**Your Ref:** LU/32/12/DOC

24 February 2012

**Article 21 of the Town and Country Planning (General Development Procedure) Order 1995**  
**Application for approval of details reserved by condition 5 & 6 of previously approved planning**  
**application LU/350/11**  
**Millfield Rest Home 9 St Catherines Road, Littlehampton,**

Proposed parking for cycles AND MOTOR VEHICLES

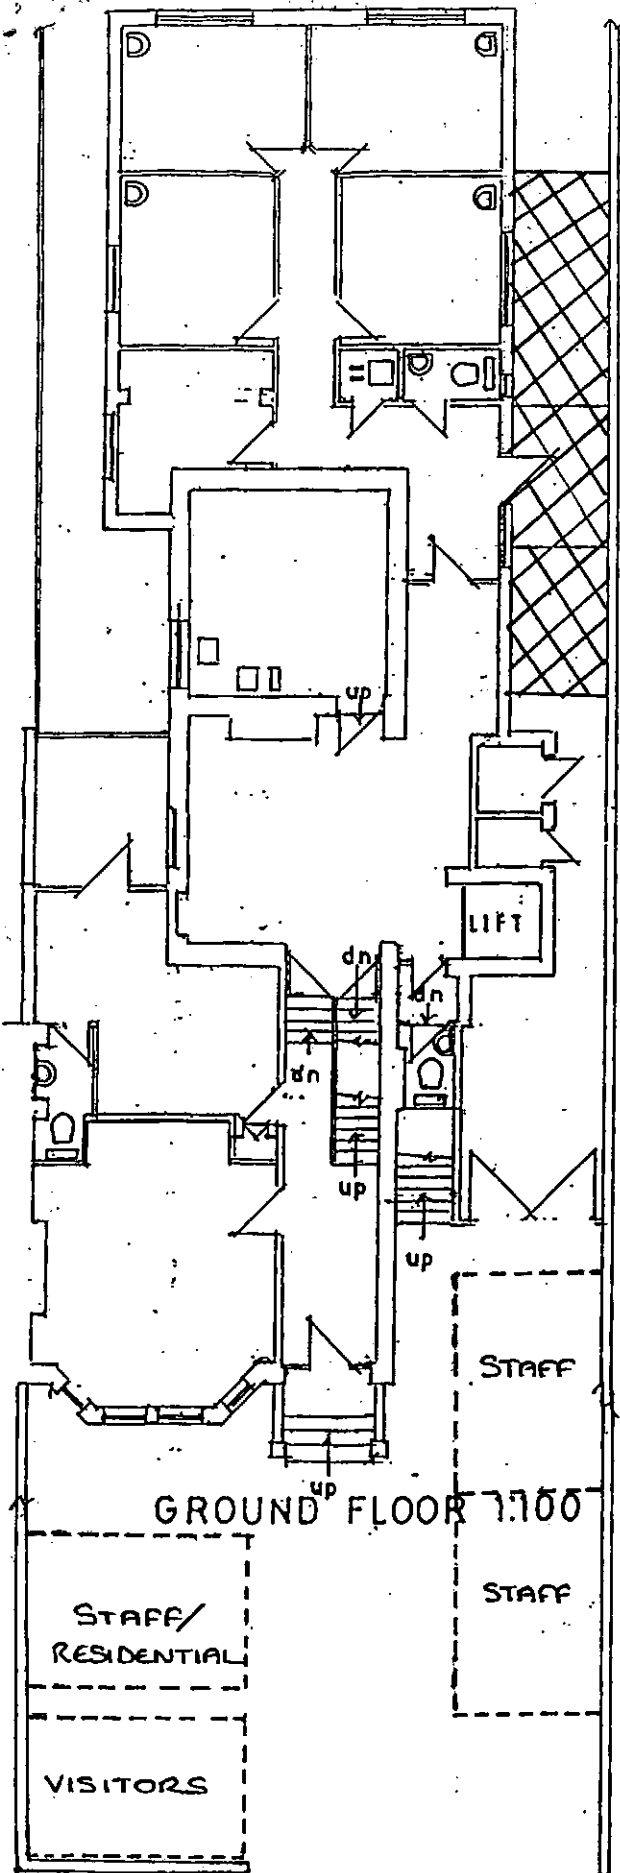
Arun District Council have decided to **APPROVE details reserved by this condition**  
West Sussex County Council Highways Department has confirmed that the parking provision is sufficient with 4 off street parking spaces being provided. They have noted that the layout means that vehicles may be blocked within the site and that this also prevents a turn on site facility when all spaces are in use, however they do not consider this to be detrimental to highway safety given the highway visibility at the junction of the driveway and St Catherines Road, therefore the layout is considered to be acceptable. The Condition is therefore discharged in so far as the submission of details relates and refers to Drawing 1 (Proposed parking for cycles and motor vehicles).
